AIR NAVIGATION, AIRSPACE AND AERODROMES BRANCH

CASA Ref: F23/1376-34

KOGARAH GOLF CLUB DEVELOPMENT - CASA COMMENTS

CASA received a request for advice from DPHI in relation to the Kogarah Golf Club Redevelopment - Concept & Stage 1 Works. Relevant documents include an Aeronautical Impact Assessment (AIA) by Strategic Airspace of 13 May 2026 and a Wind Shear and Turbulence Assessment by CPP of 18 May 2026. The AIA considers the NASF Guidelines, which is appropriate for a large building development near an aerodrome. For simplicity and synchronicity, comment on each relevant NASF Guideline follows:

Figure 4-3: Site in relation to the Windshear Assessment Areas

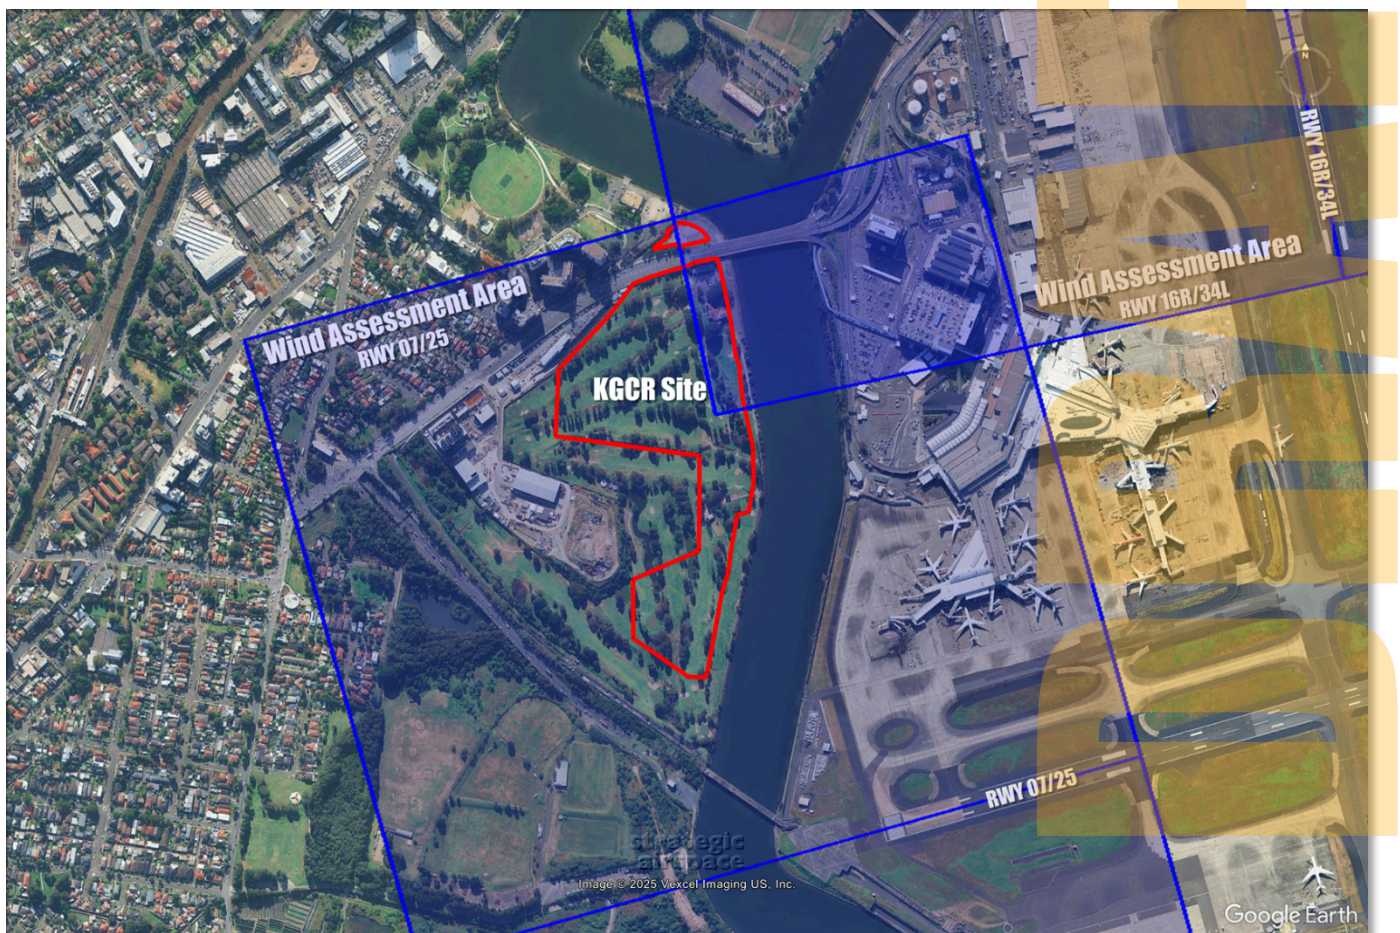
AIA Section 4.2. It is noted that wind tunnel testing was carried out by expert consultant CPP. The primary criterion is cross wind shear. The 3 second gust wind speed needed to exceed the NASF 6 knots cross wind shear limit is above 60 knots. As CPP advises; 'well in excess of operational wind speeds'. Therefore, windshear for aircraft approaching runway 16R is under control.

The tests concluded that the 3 second gust wind speed needed to exceed the NASF 4 knots root mean squared turbulence limit is above 24 knots - the same as for existing conditions. CASA is not concerned because the NASF turbulence is effectively simplified turbulence – a measure of how much the wind speeds up and slows down ... the criterion is problematic to measure and quantify and doesn't allow for rapid changes in height and direction and any swirling effects.

It is noted that runway 07/25 was not modelled or analysed on the assumption that aircraft would be landing on runway 34L or 34R in northerly winds. Also, the modelling was based on aircraft landing on runway 16R in westerly winds. As the developer of operational procedures for the various wind directions/speeds, and the holders of the runway usage

statistics, Sydney Airport should review the CPP Wind Shear and Turbulence Assessment and confirm the assumptions made.

A wind from approximately 290° would pass through the (lower rise) south end of the development site to the runway. Landing aircraft (on runway 07/25) would approach from the east in a 290° wind and therefore not be a problem. Departing aircraft are less affected by wind effects than approaching aircraft and departing aircraft will normally be well above the affected area. However, the reasons why runway 07/25 was not modelled could be explained in more detail (in the AIA or CPP Assessment).
